# Rezoning Transportation Analysis

Petition Number: 2022-190

## Revision Log:

Date	Description
3-22-23	First Review (IW)

**RZ-1.0**

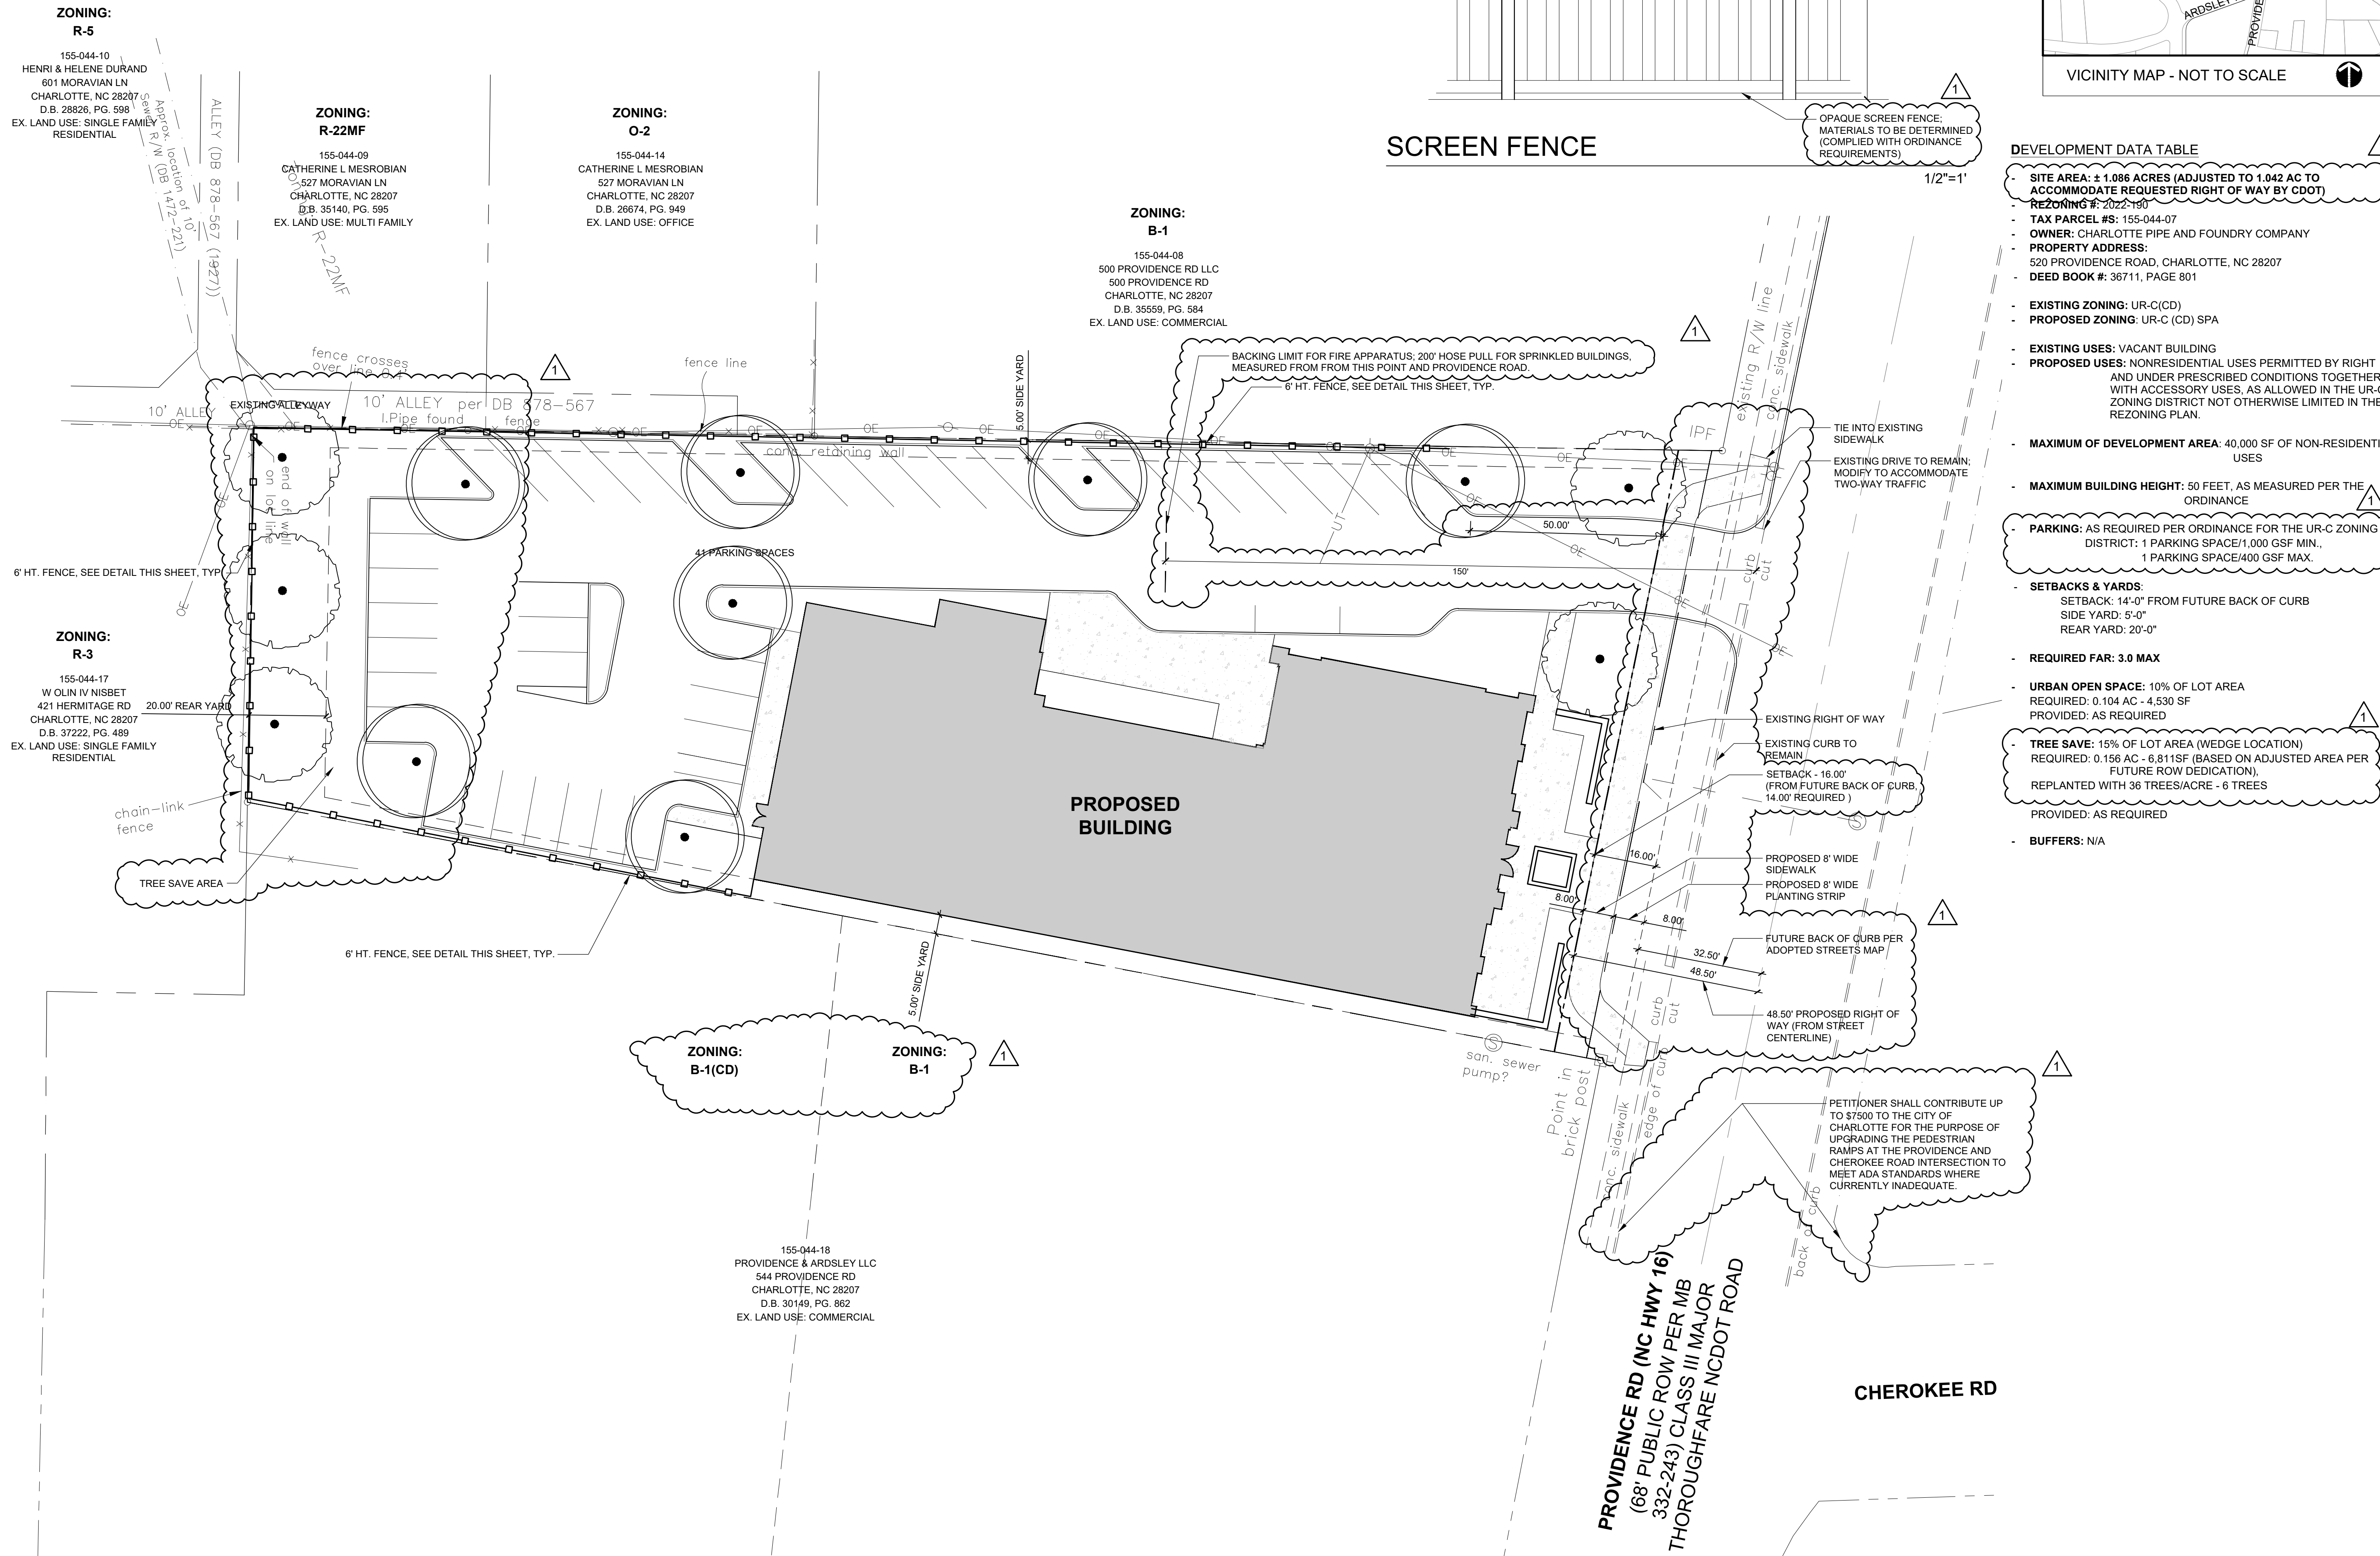
**Providence Road:** Future location of curb and gutter to be 32.5 feet from roadway centerline to accommodate the Charlotte Streets Map with a roadway typical section of 4 Avenue, buffered/separated bike lane.

Label and dimension the curb and gutter from the centerline for each road on the site plan.

3. Revise site plan and conditional note(s) to commit to dedicate 50.5 right-of-way from the road centerline. The site plan shall label and dimension the right-of-way from the road centerline.

5. CDOT request the site plan and conditional note(s) be revised to commit to a 50-foot driveway stem behind the right of way per NCDOT coordination.

6. CDOT requests site plan and conditional note(s) be revised to commit to upgrading intersection for ramps to meet ADA standards and upgrading pedestrian crossings for APS.
